Ribble Valley Borough Council
Housing & Development Control

Application no: **3/2023/0100**

Address: **Land west of Preston Road Longridge PR3 3BE**

Proposal: **Residential development of 91 units (plots 150-222 and 251-268) together with access roads, 200sqm community hall and associated parking, landscaping, footpaths, public open space and children's play area (amendment to previously approved reserved matters scheme 3/2021/0470 involving re-plan of site and net gain of 12 residential units).**

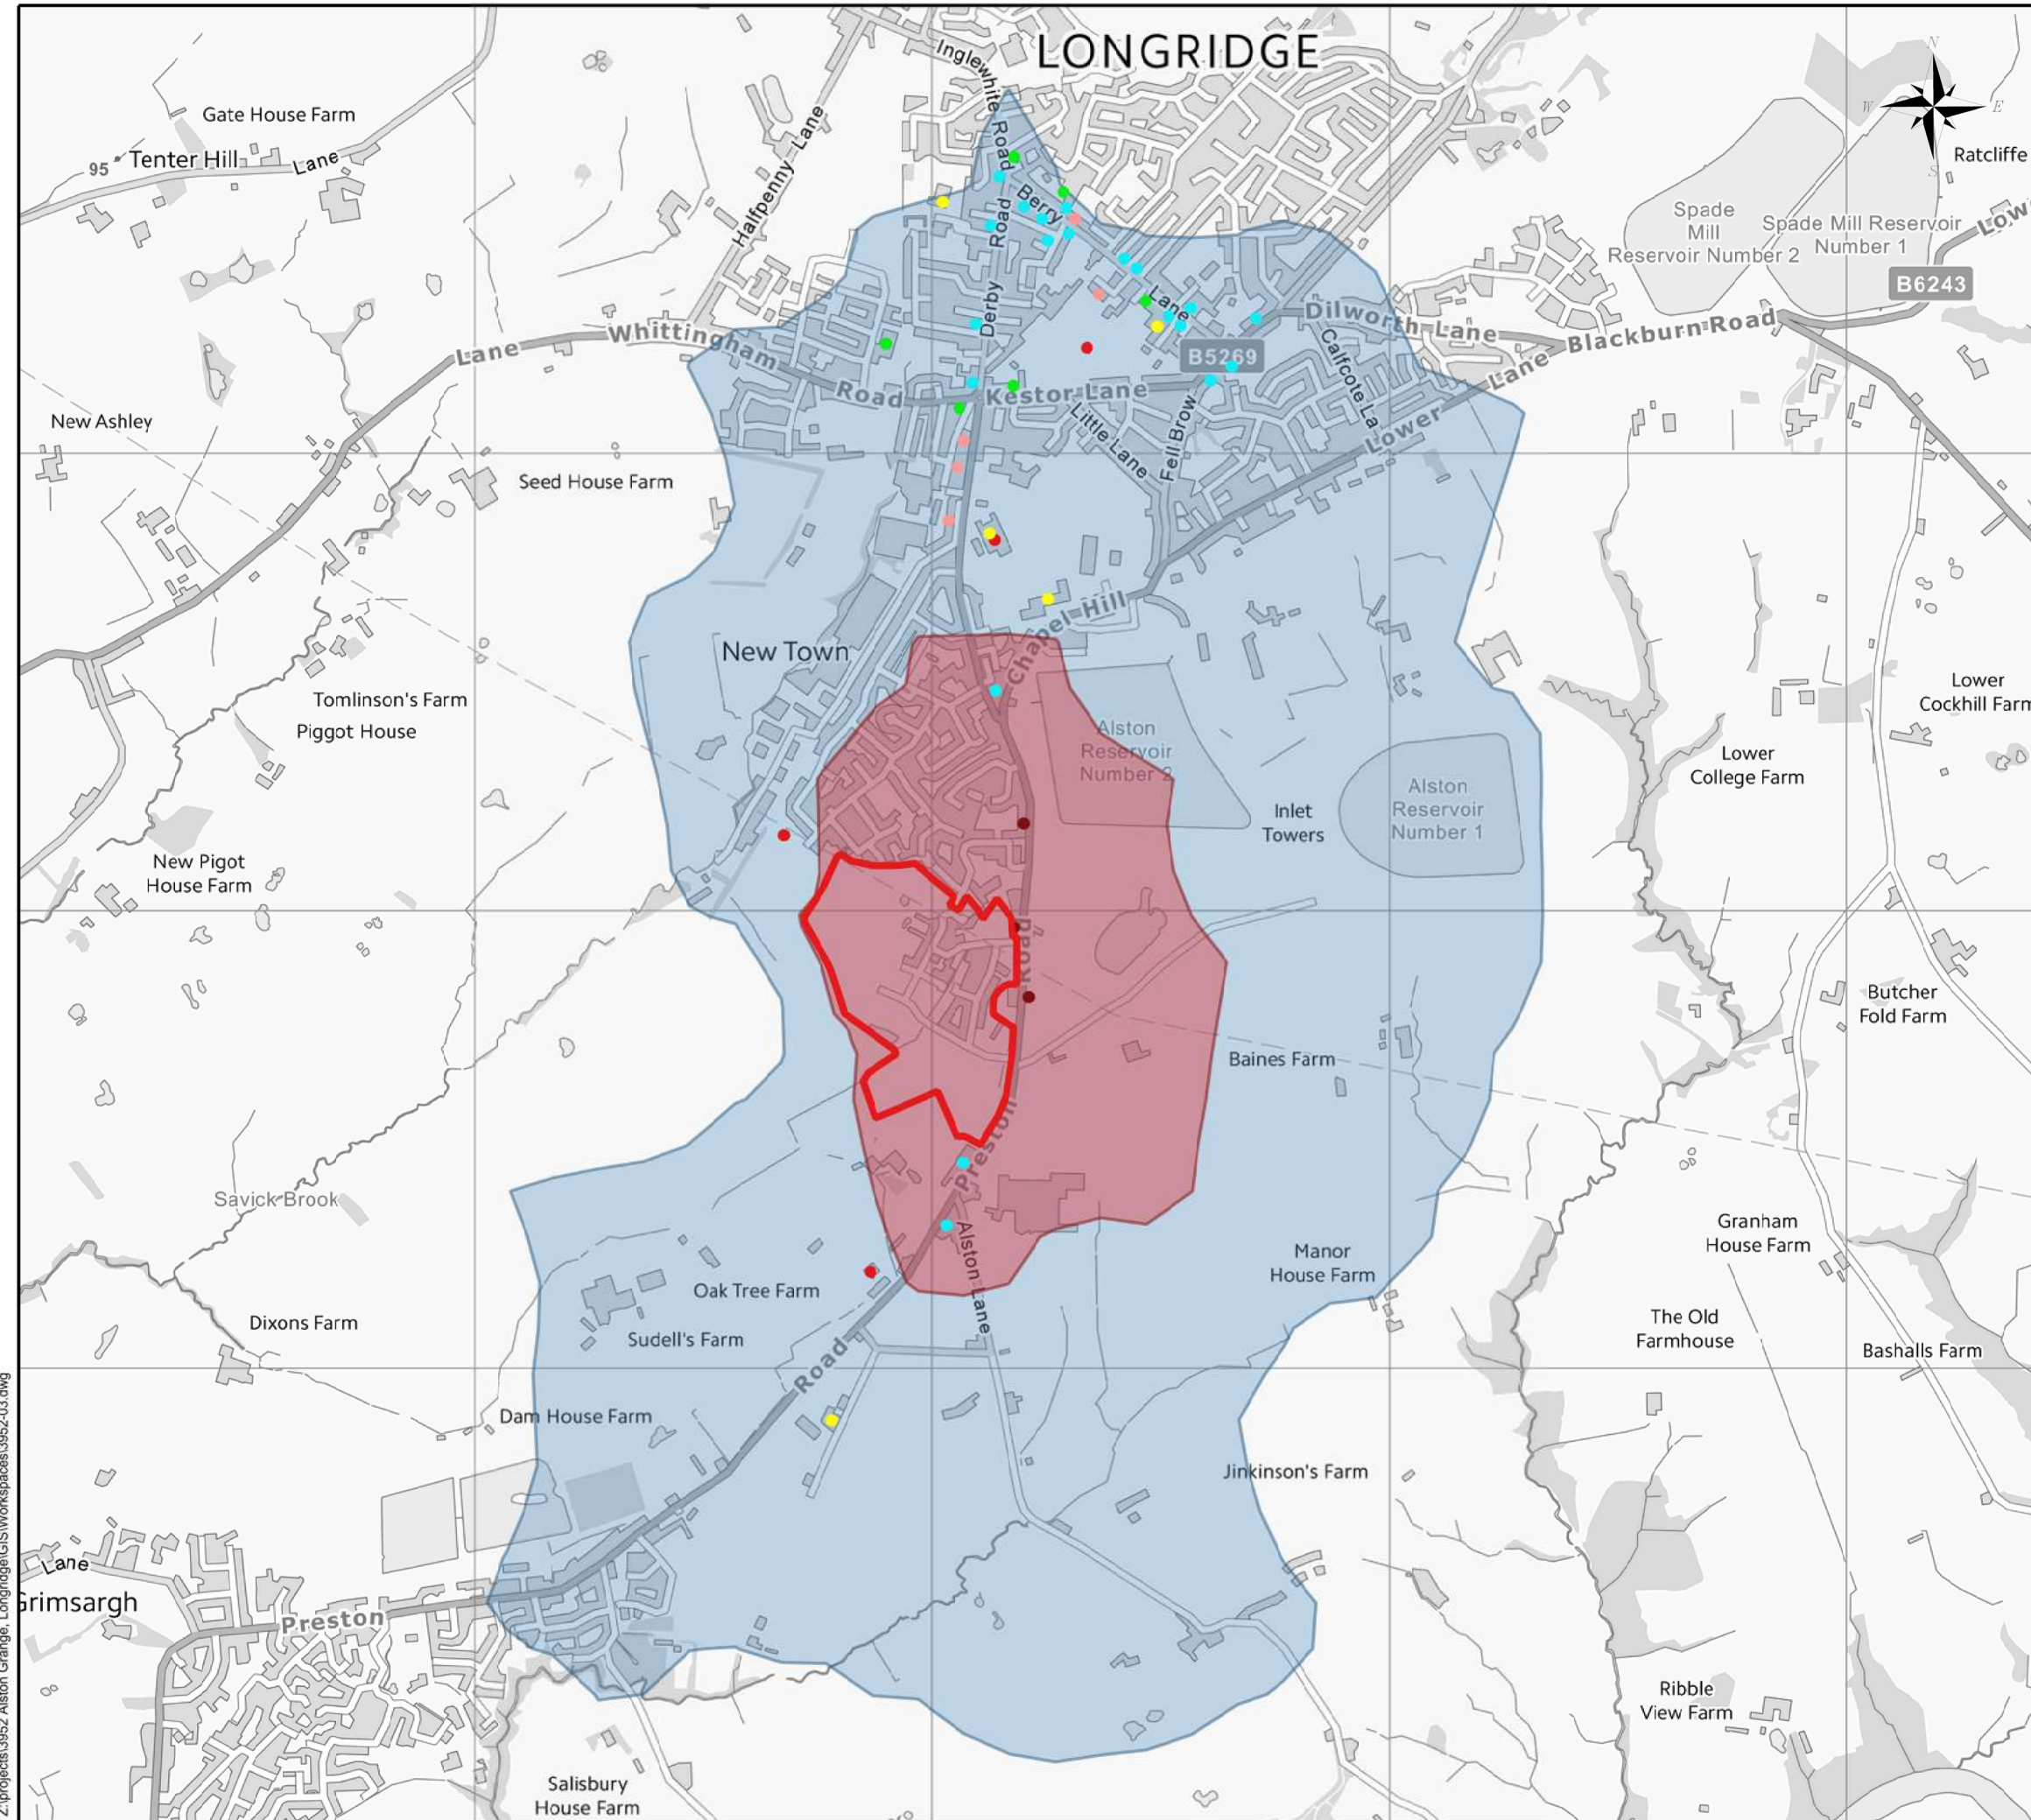
The LHA have drawing number PL01 Rev F titled "Planning Layout- Replan (Plots 150-222 inc and 251-268 inc)" and are aware that the main spine road throughout the site will be 5.5m wide. However, the width of the carriageway will reduce to 4.8m when the spine road connects to a junction which serves a cul-de-sac, for example the carriageway reduces to 4.8m when serving Plots 158-166.

While this does not comply with the LHAs guidance which requires the adopted internal carriageway to be a minimum of 5.5m throughout the site, the LHA in this case will accept the reduction in carriageway width to 4.8m when it serves a cul-de-sac which has a turning area. This is because during the permitted reserved matters application 3/2018/0105, the LHA accepted this feature as shown on MPSL drawing number 01 Rev C titled "Planning Layout". Therefore, it would be unreasonable to request that the internal carriageway is 5.5m wide throughout for Phase 3, while Phase 1 and 2 which has already been built, remains 5.5m wide for the spine road but the carriageway is able to reduce to 4.8m wide when serving a cul-de-sac. Therefore, the LHA have no concerns regarding the carriageway width.

The LHA are aware that Plots 150-151; 160-161; 162-164; 172-173; 199;200 and 256-258, will all be accessed from private, access tracks. The LHA have no objection to this but will request that a Private Management Company is established to maintain the areas which aren't going to be adopted.

The LHA have further reviewed drawing number PL01 Rev F and are aware that each plot will have access to an electric vehicle charging point and cycle storage will be provided in each individual Plots garage or in an adjacent storage facility such as a shed. The LHA welcome the introduction of these and will condition these below.

The LHA have reviewed drawing number PL01 Rev F and are aware that the site will provide an off-road pedestrian link from Pond 6 to Pond 7, which connects the area to the surrounding site and provides internal off-road links to the already approved 3.5m cycleway which is located at the northern boundary of the site.

The LHA welcome these links but will request that the route is paved, drained and lit to an adoptable standard.
